Application no: **3/2022/0935**

Address: **Read and Simonstone Village Hall 6 East View Read BB12 7PS**

Proposal: **Retention of unauthorised change of use from former private allotment to new outdoor space comprising hardstanding area, french trench, internal retaining wall with steps, vehicle access gate, tiered boundary planter wall, pedestrian access gate and post and rail fence. Outdoor space to be utilised for temporary land uses under permitted development.**

The Local Highway Authority have viewed the plans and highway related documents and have the following comments to make:

5387 -S01C

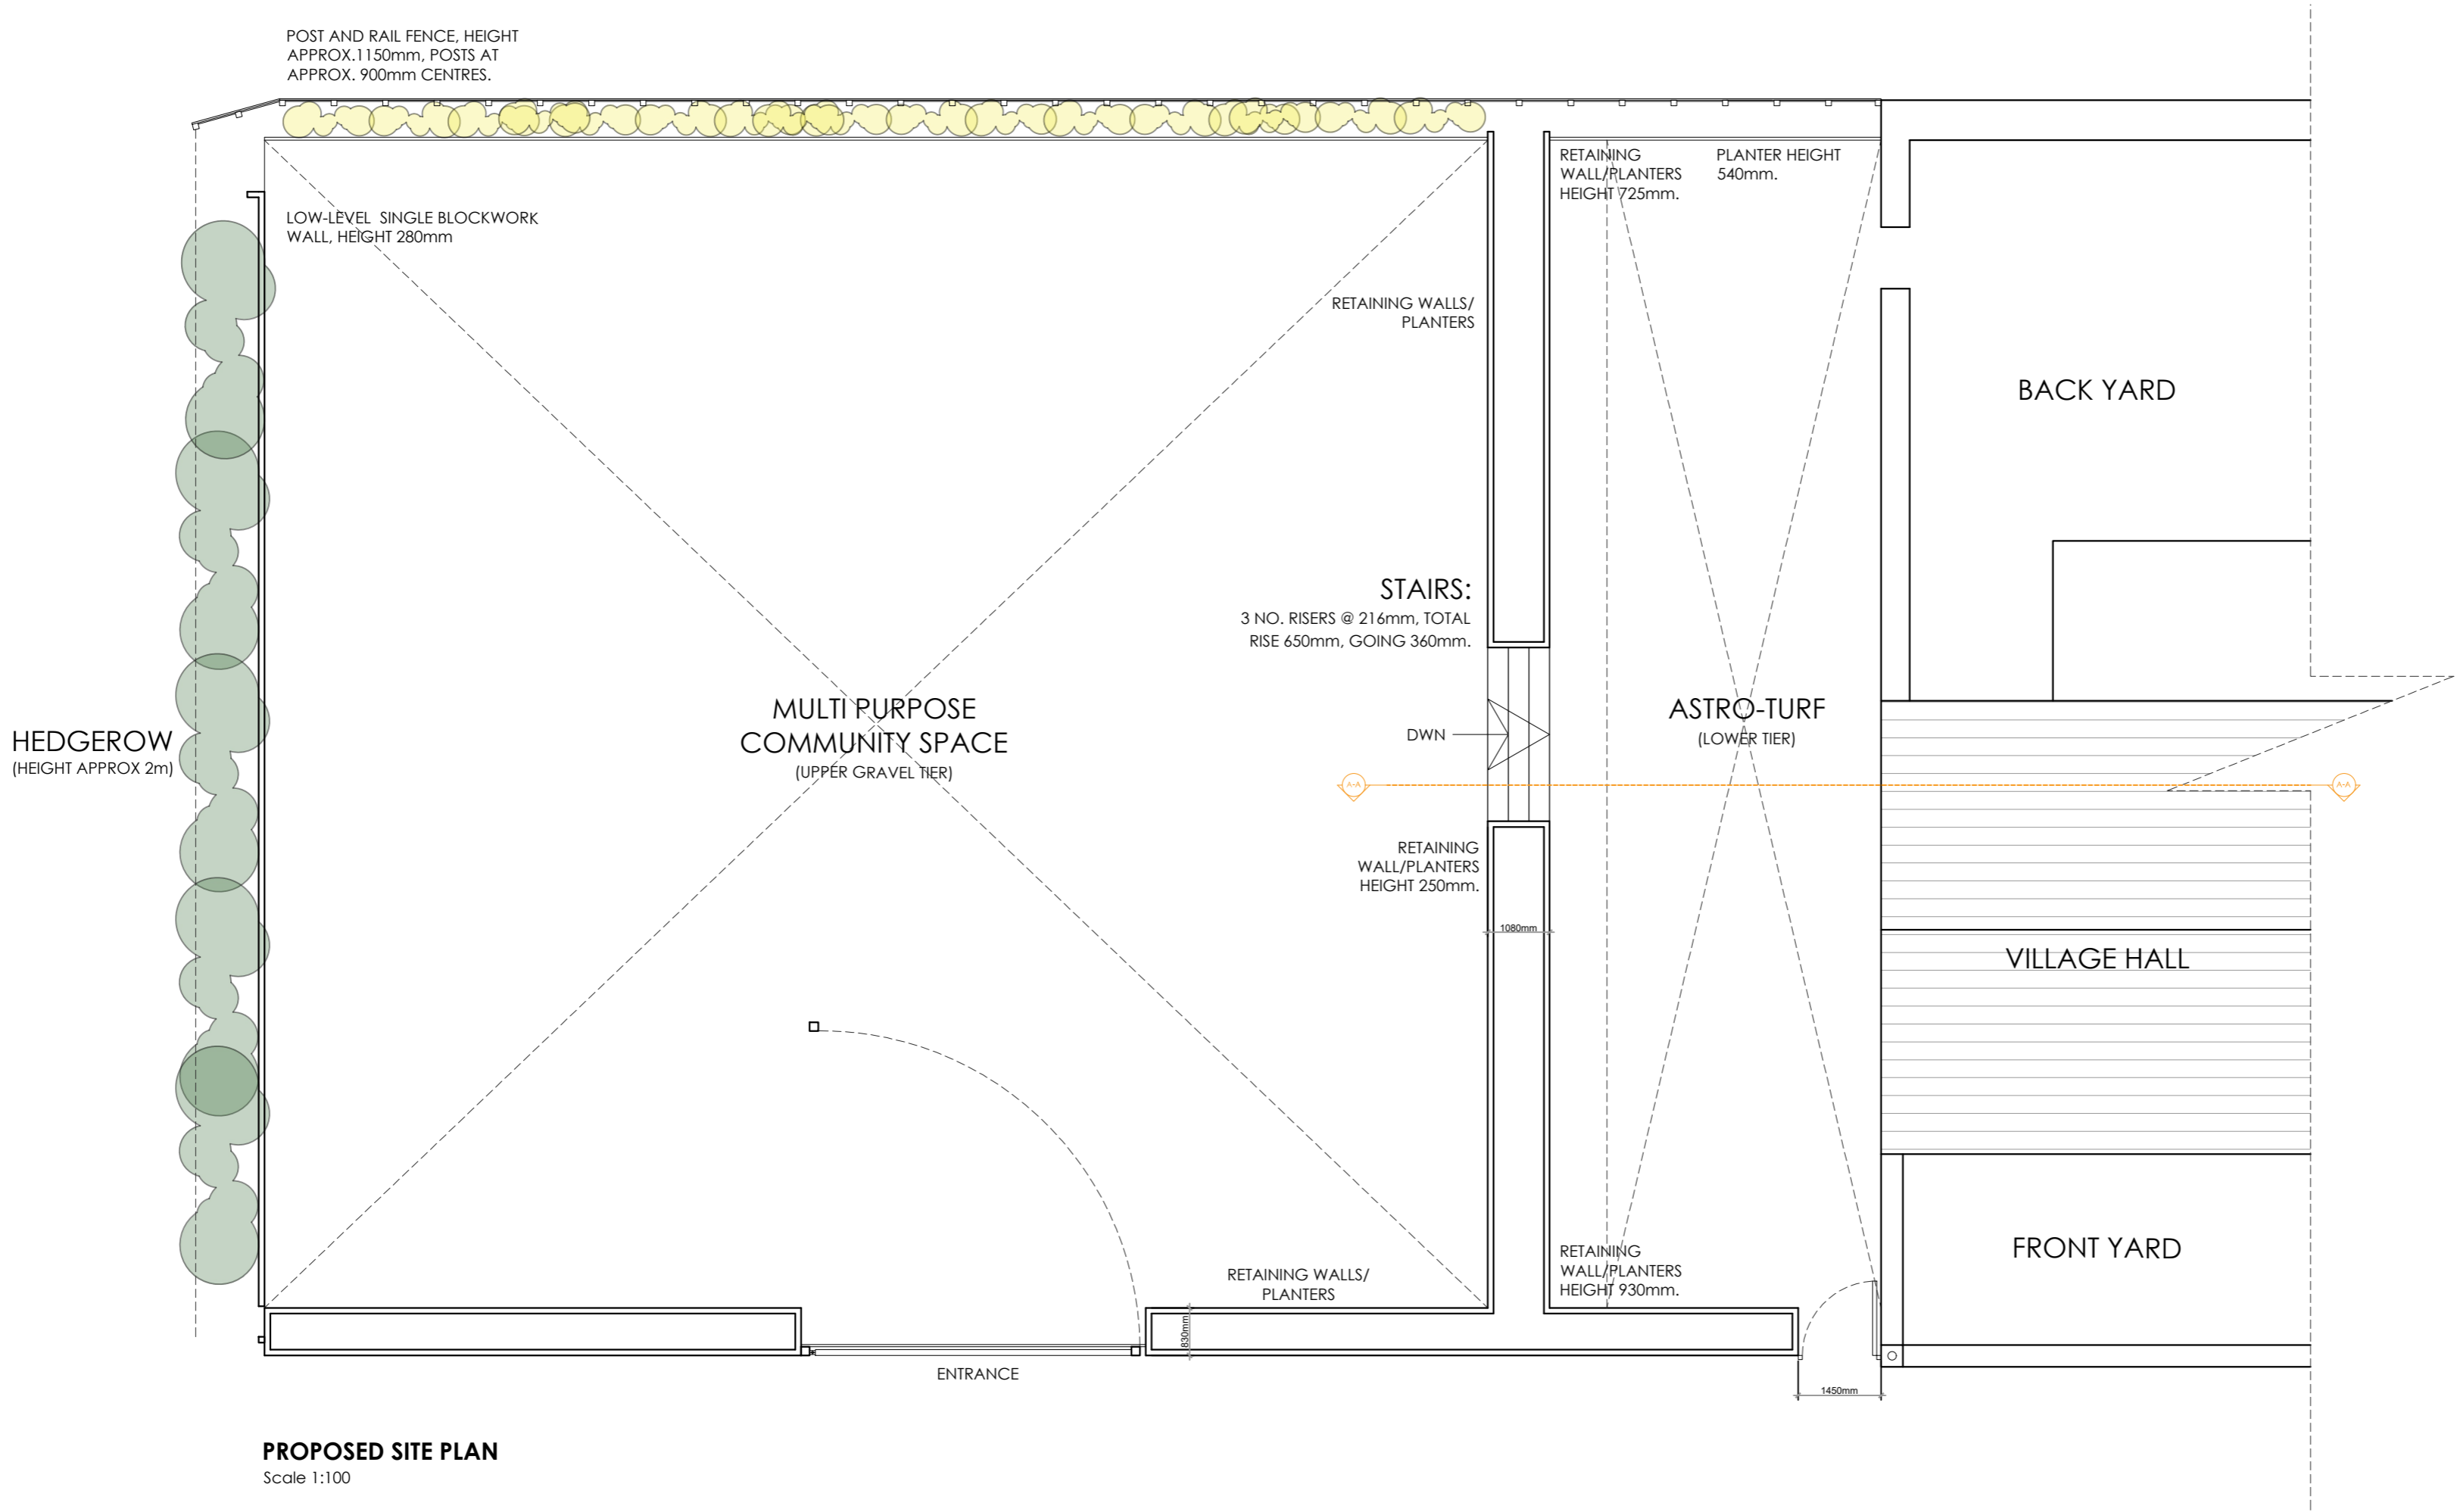
However, the LHA are aware that the location of the access will be adjacent to the crossroads junction between East View/ Tennyson Avenue/ Greenacres. The LHA are currently unable to support the creation of an access adjacent to a crossroads junction for highway safety reasons with the LHA requiring a minimum distance of 10m being between the junction and the start of the access to comply with the LHAs guidance. Therefore, to ensure that the LHA can support the creation of the vehicular access the LHA will require the access to be relocated a minimum distance of 10m from the junction.

5387 -S01a

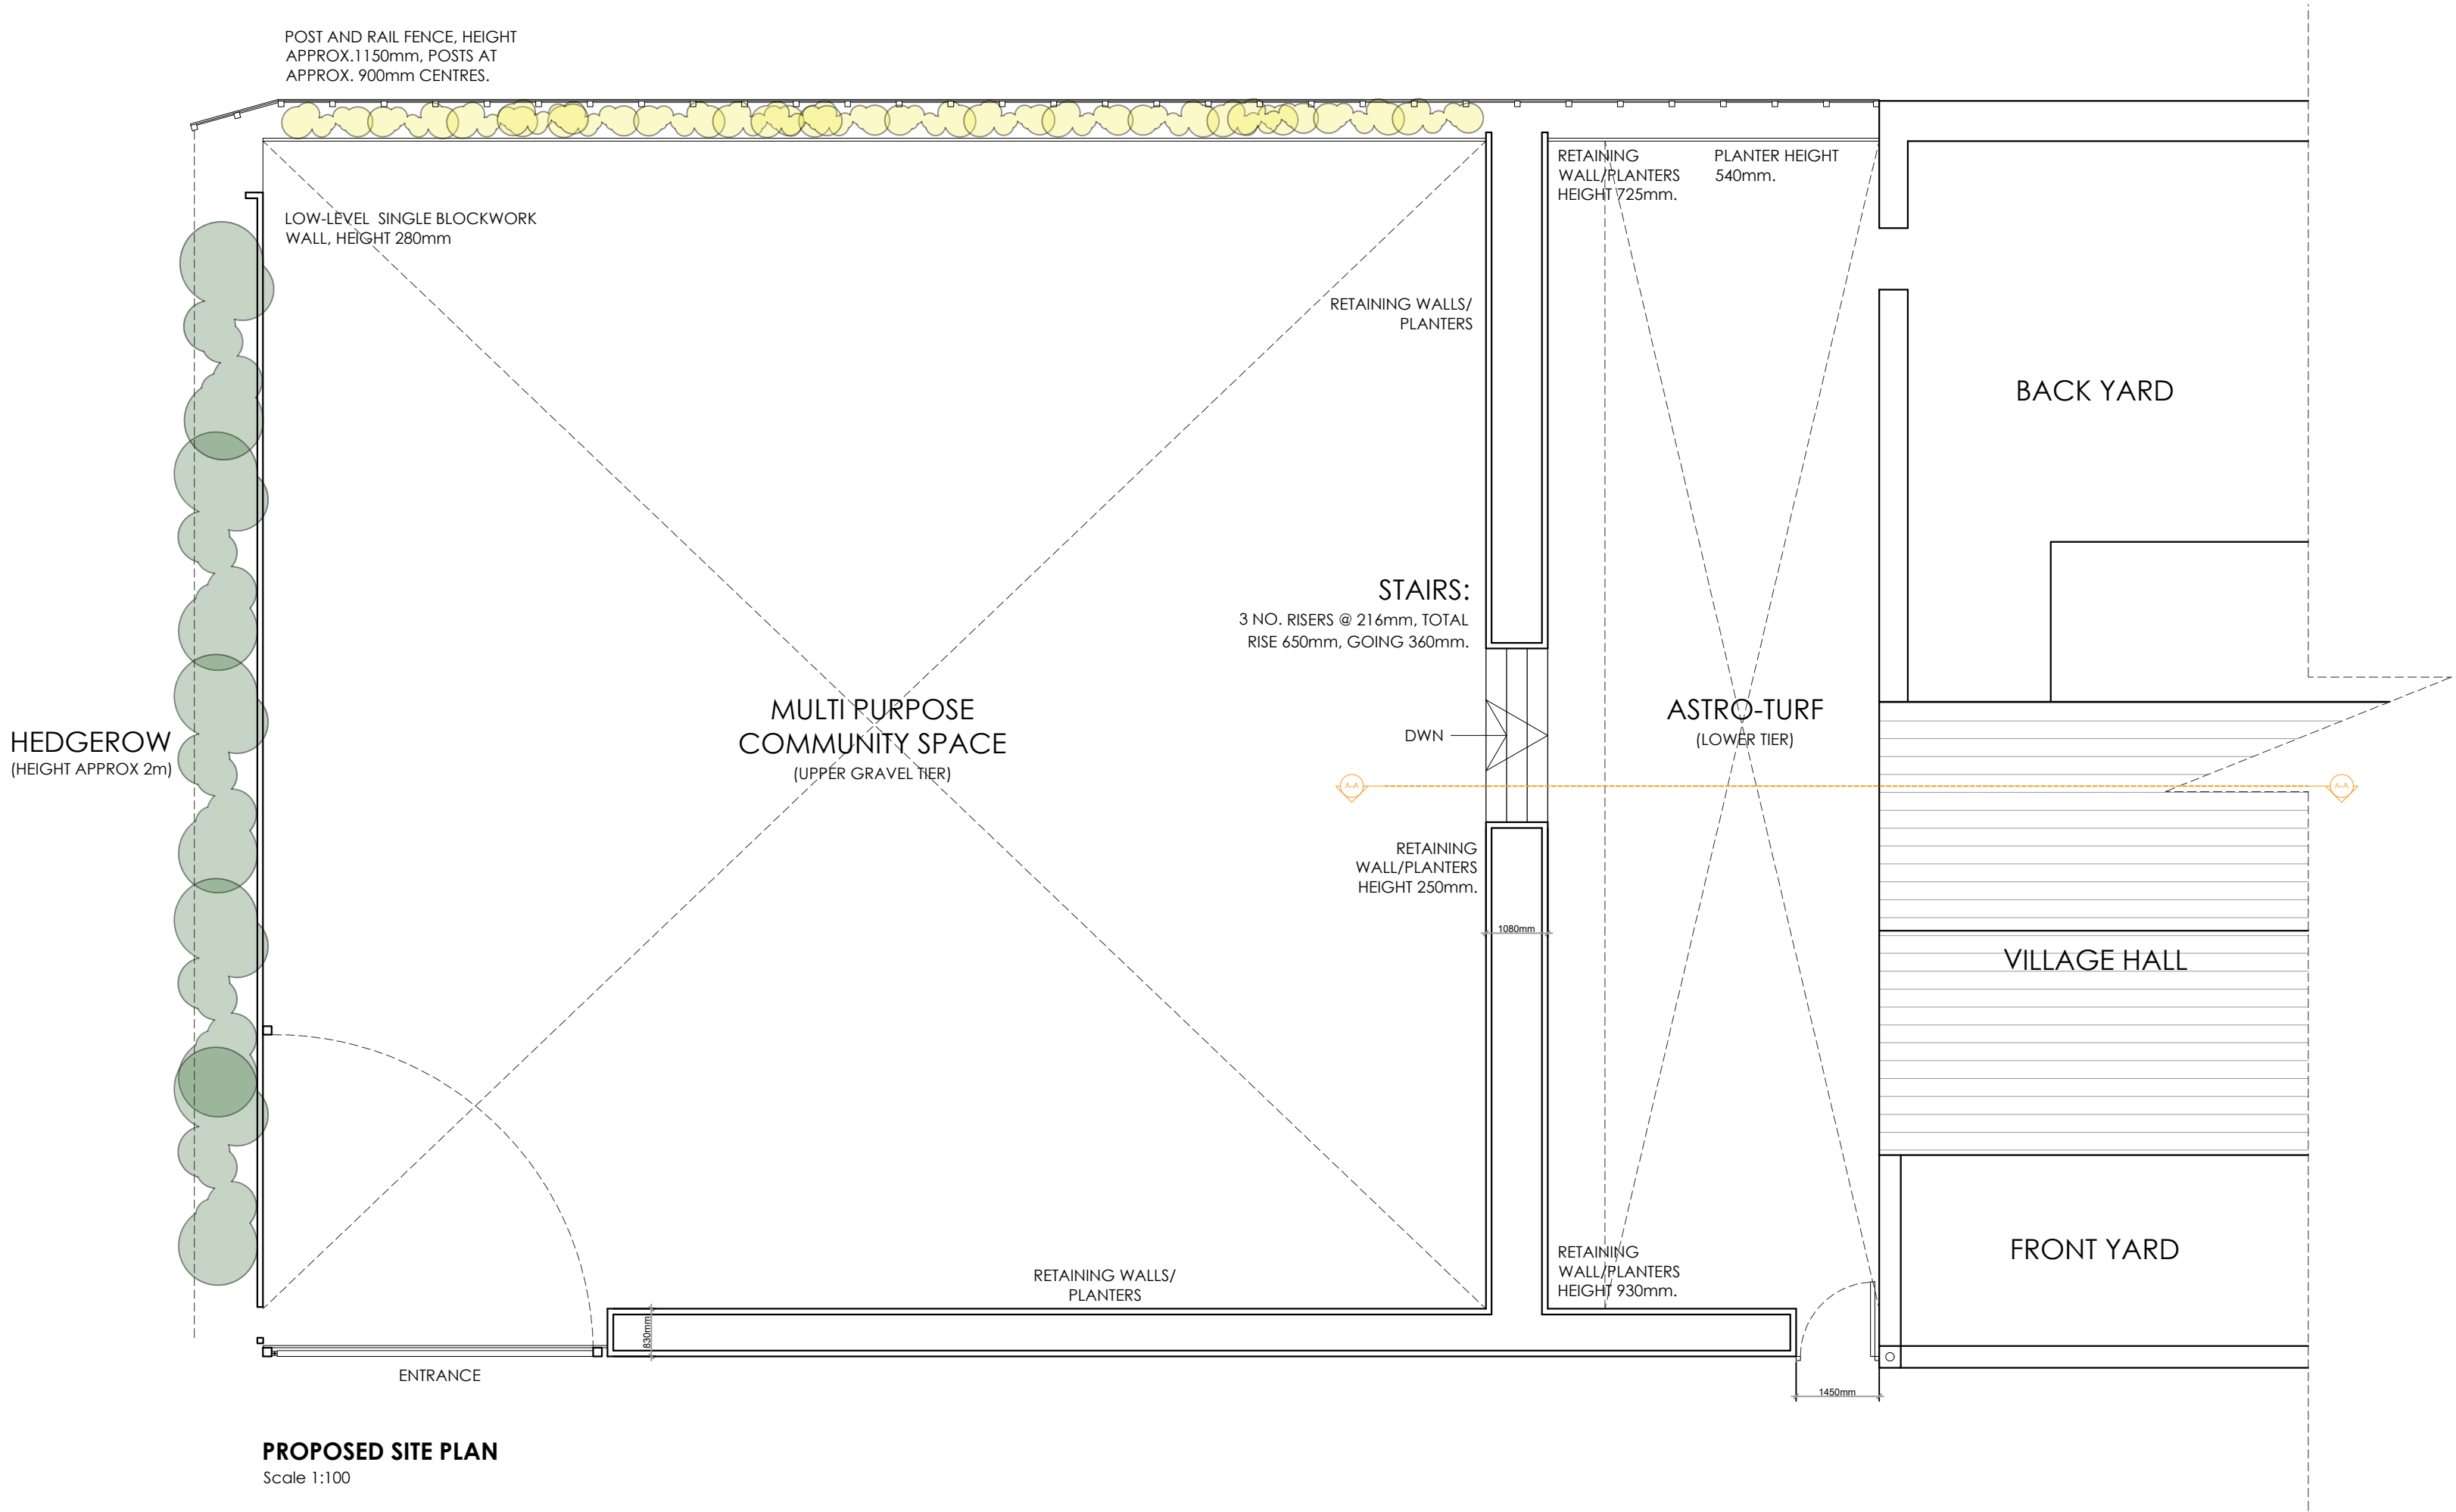
The LHA have reviewed SPA drawing number 5387 S01a titled "Proposed Site Plan" and are aware that the access will be a minimum of 6m wide, which complies with the LHAs guidance.

The LHA also require on a revised site plan, visibility splays of 2.4m x 25m to be provided in both directions given the 20mph speed limit of East View.
